Our ref: RFI-129394488

Subject: Cadia East Gold/Copper Project Modification 16 (MP06_0295-Mod-16) - Request for Additional Information

Figure 2-1 Particle Size Distribution for Recovered sand

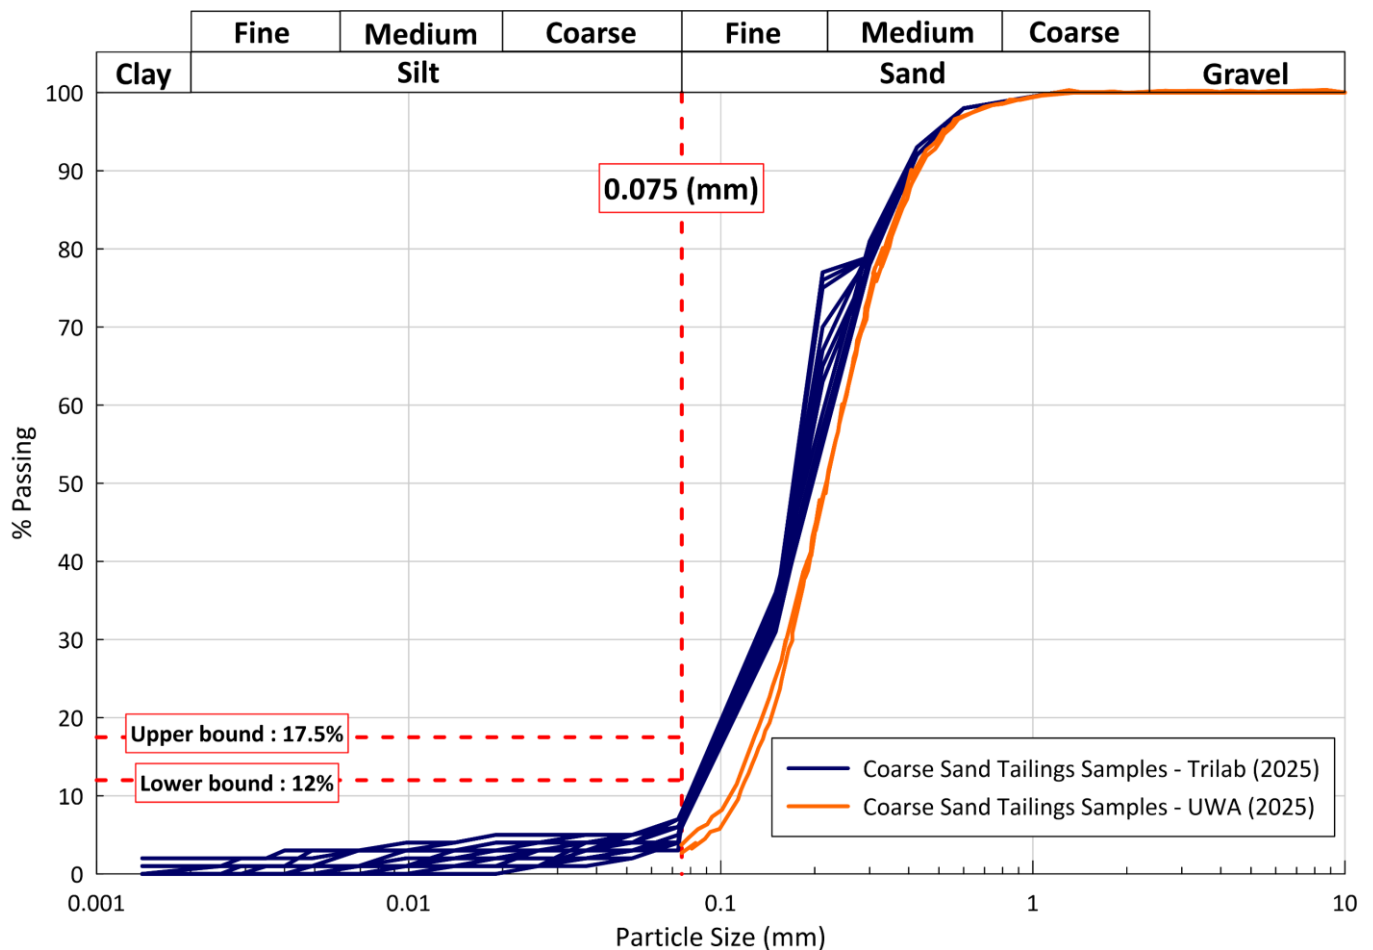
Please indicate what proportions of construction materials are planned to come from each source and the planned sequencing from each source. Further, the particle size distributions and fines content of each source appears to be quite different. Please indicate the required sand specification and how this would be achieved from the two sources or whether they would be combined in some way (including with whole tailings) to meet the specification. How would uniformity be ensured?
